Subject: RE: Application AW/24/20/HH

I am emailing you with regards to application AW/24/20/HH. As you can see in the email attached below my Team leader has felt there needs to be some screening on the balcony to the east. Is this a possibility as that would alleviate the possible overlooking on the neighbouring property. We would be hesitant to approve a balcony without the screening.

Plan 4
Proposed First Floor
15 Shorecroft – Aldwick

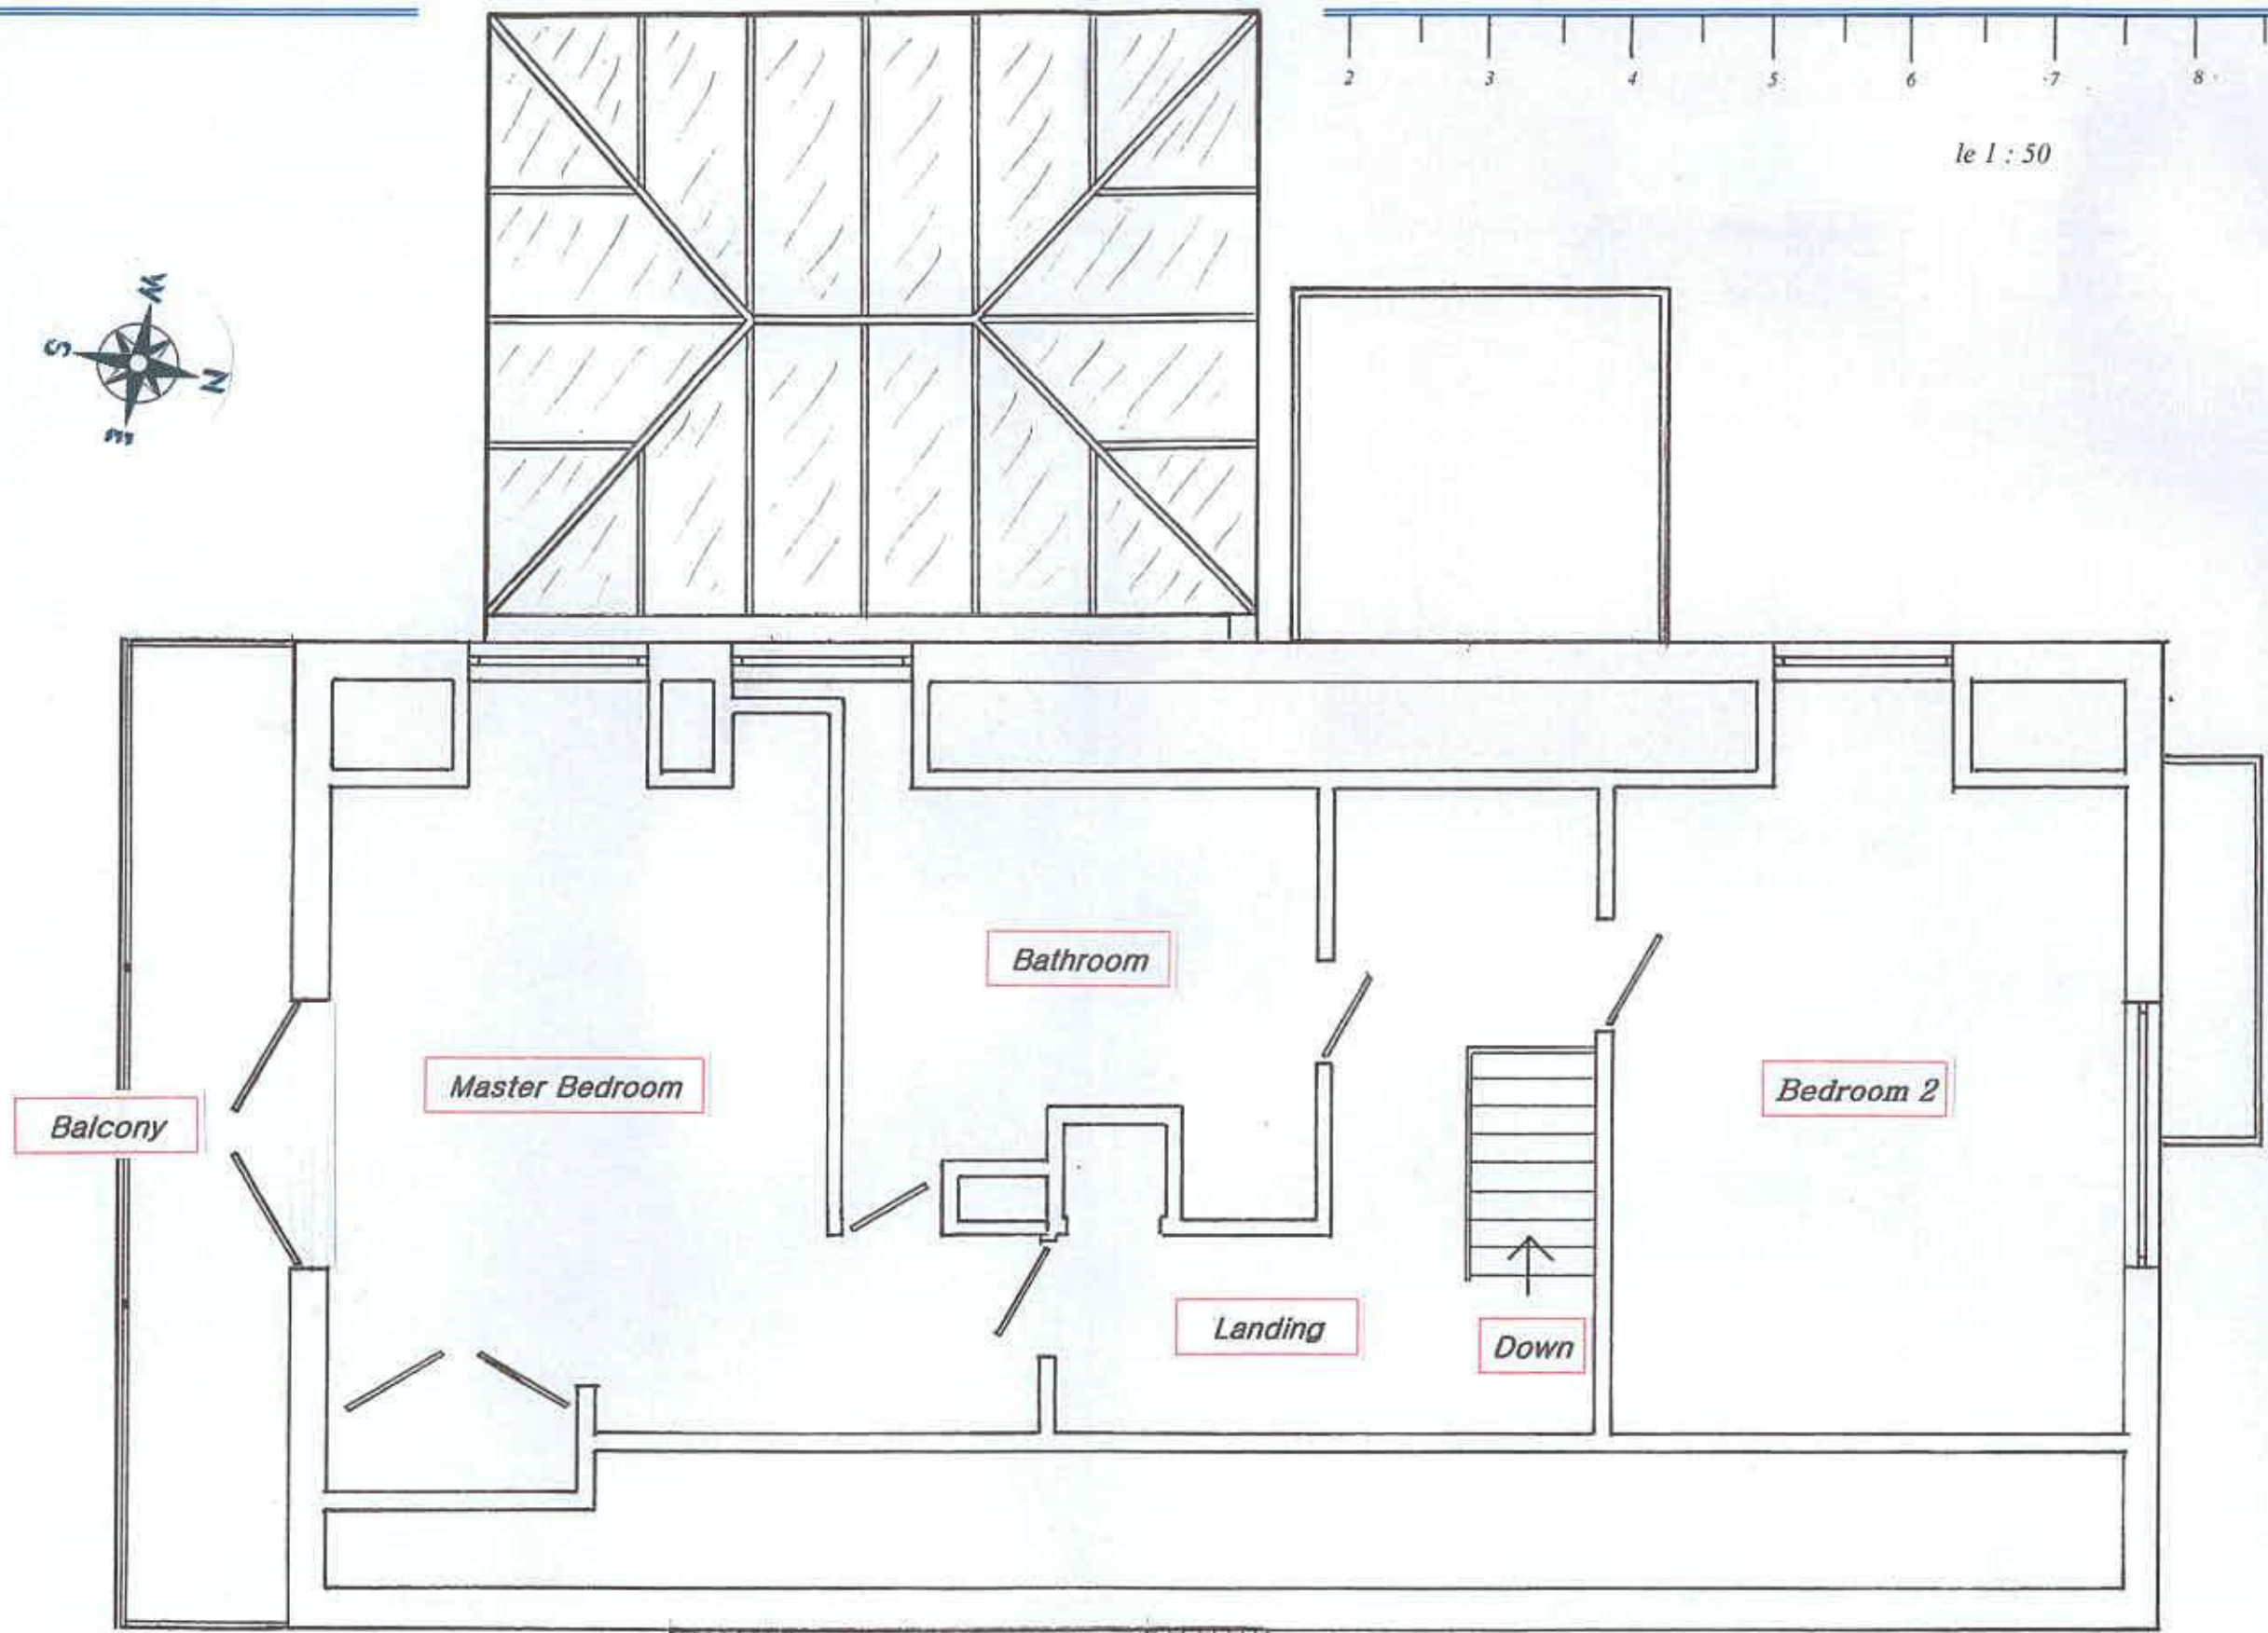
I apologise with the time your application has been with me, I have spoken to my team leader and he has raised the possible overlooking to the east. As such will you be able to put a screen on the balcony to that side to alleviate that problem? If so I should be able to get a decision to you in the next couple of days.

I have planned on putting opaque glass on the East end panel of the balcony because it also gives me some privacy from next door. However I spoke to the owner of next door and she said she had no reservations with me having a balcony as she said we both already have windows that overlook each other.

*Plan 10
Proposed East Elevation
15 Shorecroft – Aldwick*

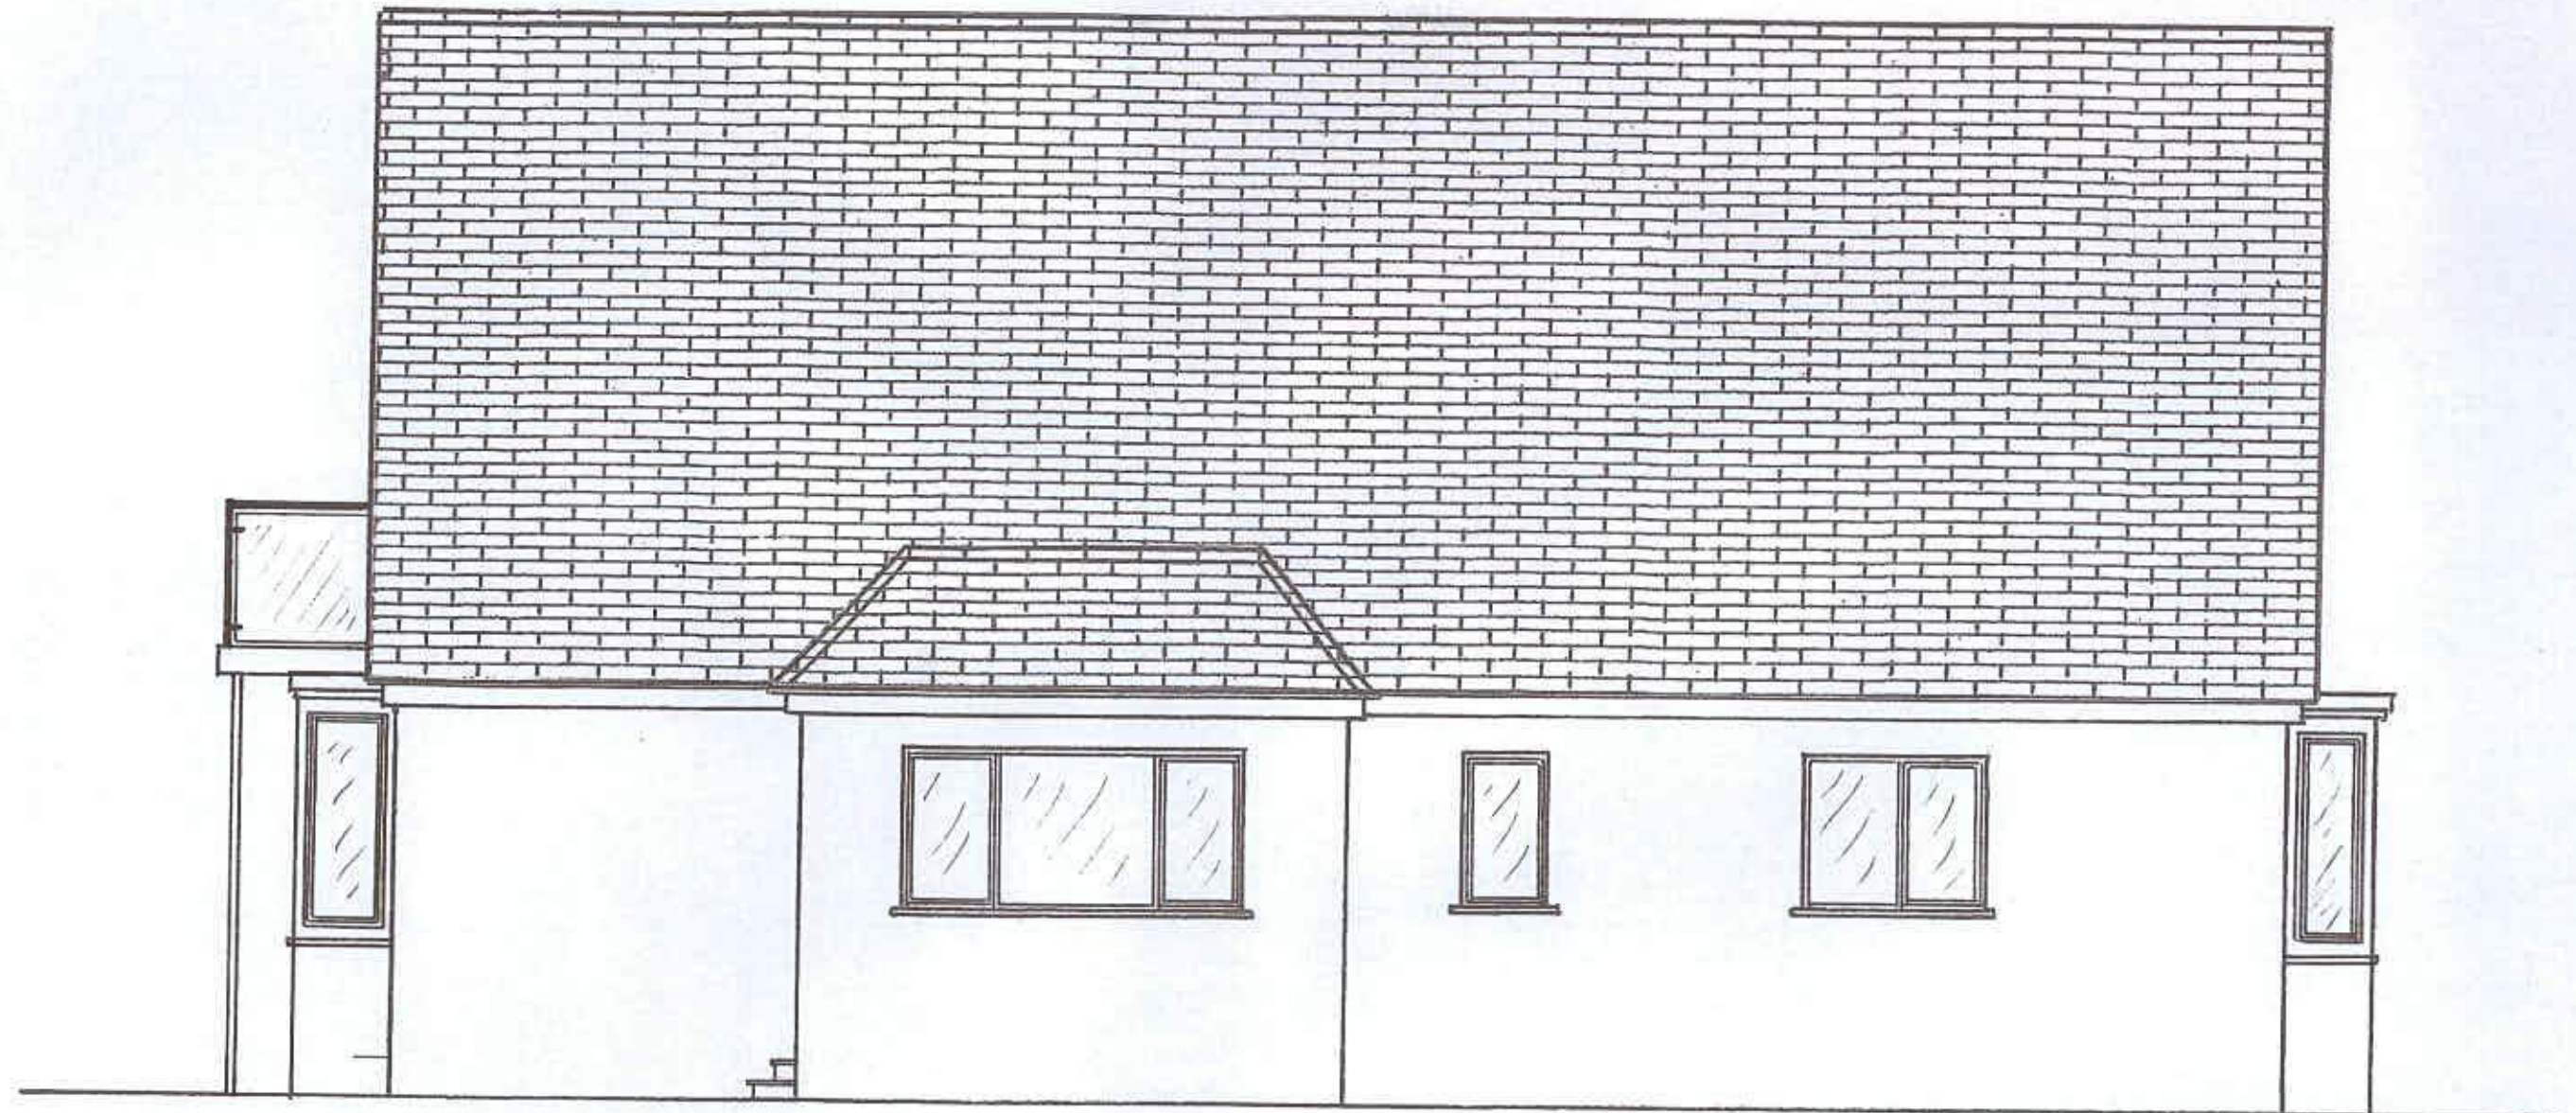
The height on the screens would be 1.7m to avoid overlooking. Would you agree to one until the 21st of this month (next Thursday)?

Hi Finlay , yes we agree
